On the description / development it should be noted when it says demolition of existing conservatory and erection of single storey side extension (within a Conservation Area) the reason for the demolition is due to the home owners of Kelvin Villa, 1 Newsome street building the single storey illegally without planning permission initially.

This new application should be rejected by the council due the height being too high, the height has never been this high for this property, also this property has never had a flat roof and the front elevation comes out to far which in result takes the extension pass the house.

PROPOSED FRONT ELEVATION
1:100 @ A1

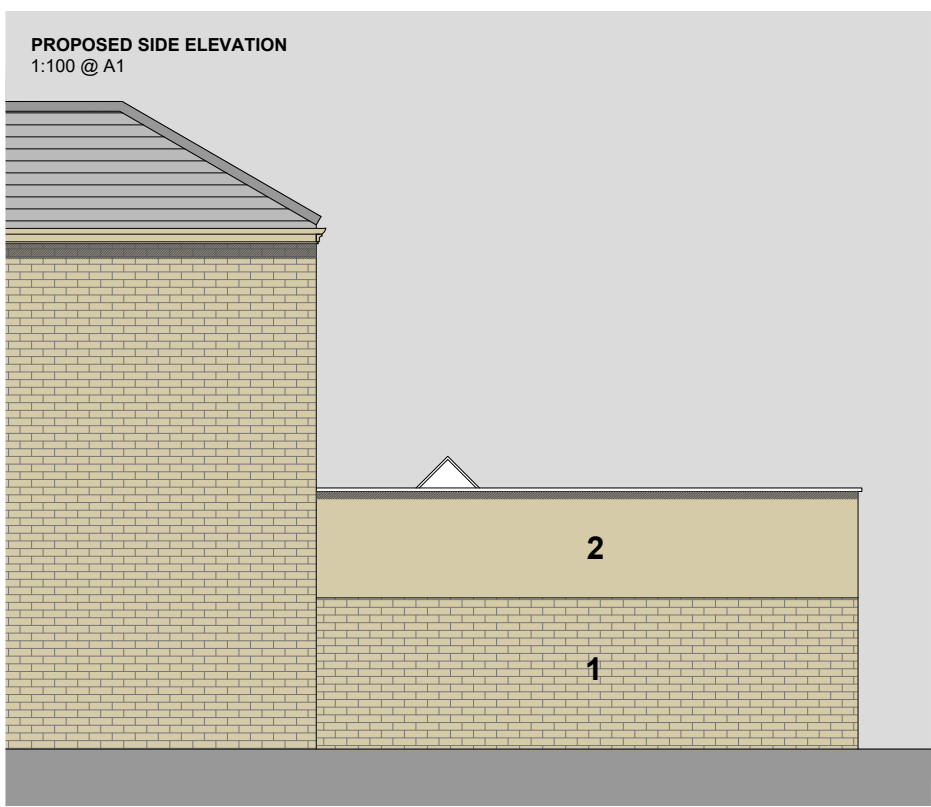
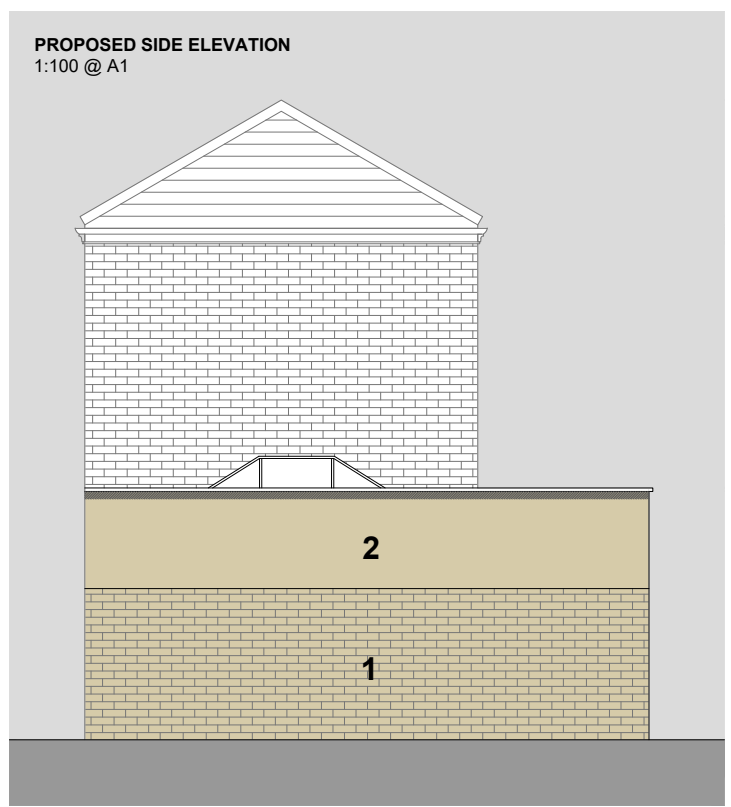
The proposed hight on the new application is too high, in whole will make the area look heinousness

The rear elevation materials must match the current property, they should not be using rendering anywhere. In fact, all the materials/bricks on the front, side, rear should match the current property. Rendering mustn't be used at all as this will be inappropriate within a conservation area.
